Huntlee – Stage 1 MP10_0137 Modification 20 – Response to Submissions

Ethos Urban has prepared this letter for Huntlee Pty Ltd regarding the section 4.55(2) Modification Application (MOD 20) to Project Approval MP10_0137, relating to the Huntlee New Town, Branxton. The purpose of this letter is to provide a response to a Request for Further Information (RFI) received on 19 September 2022 from the Department of Planning and Environment (DPE). The RFI requests a response to a single public submission received on the amended application, submitted as part of a previous Response to Submissions (RTS) and two previous RFI responses. It is noted that the RFS have been requested for comment on the RTS and previous RFI responses however no comments have been received.

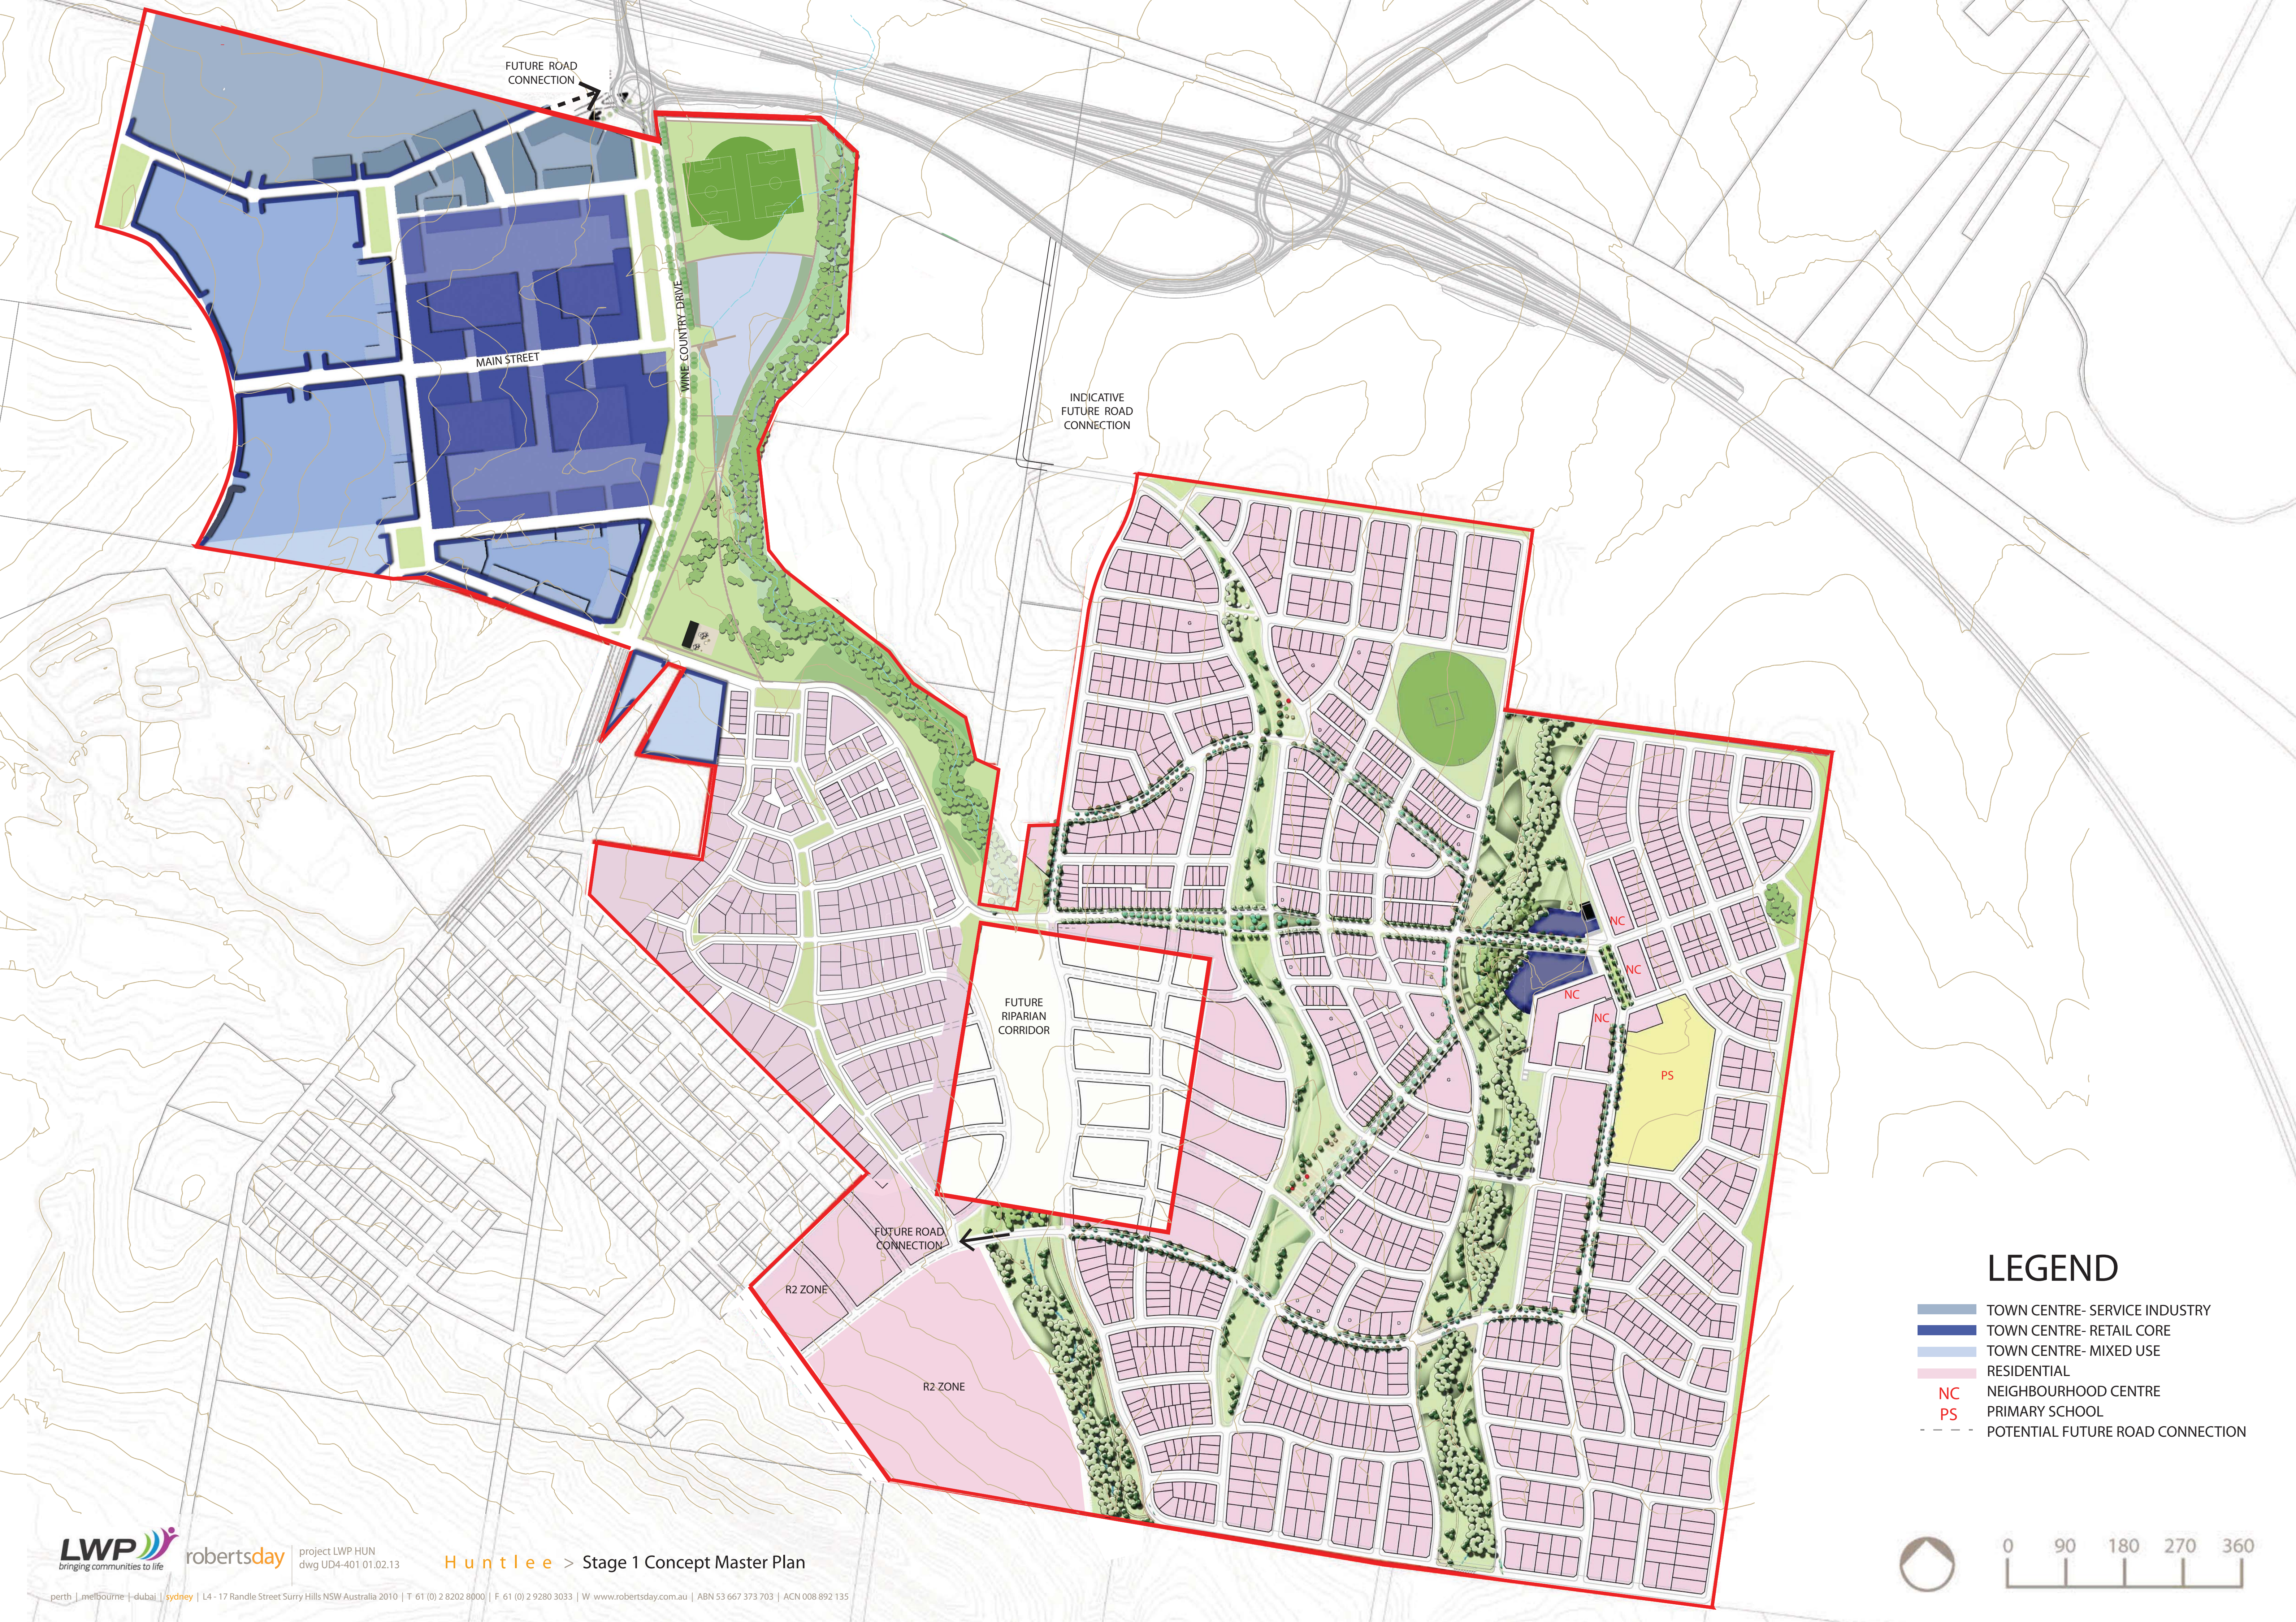
The proposed subdivision layout adjoining the eastern side of Lot 34 DP755211 still does not comply with the Huntlee DCP, specifically regarding the provision of road and services connectivity to Lot 34.

The Huntlee DCP provides for a Local Park Edge Street along the riparian corridor on the east of Lot 34 (shown in **Figure 1**). Modification 20 is consistent with this road layout, providing a Local Park Edge Street in the same alignment as the DCP. The infill residential allotments east of Lot 34 are generally accessed from this Local Park Edge Street, providing consistency with the DCP. Services within the road corridors in this location can be extended into Lot 34 as required.
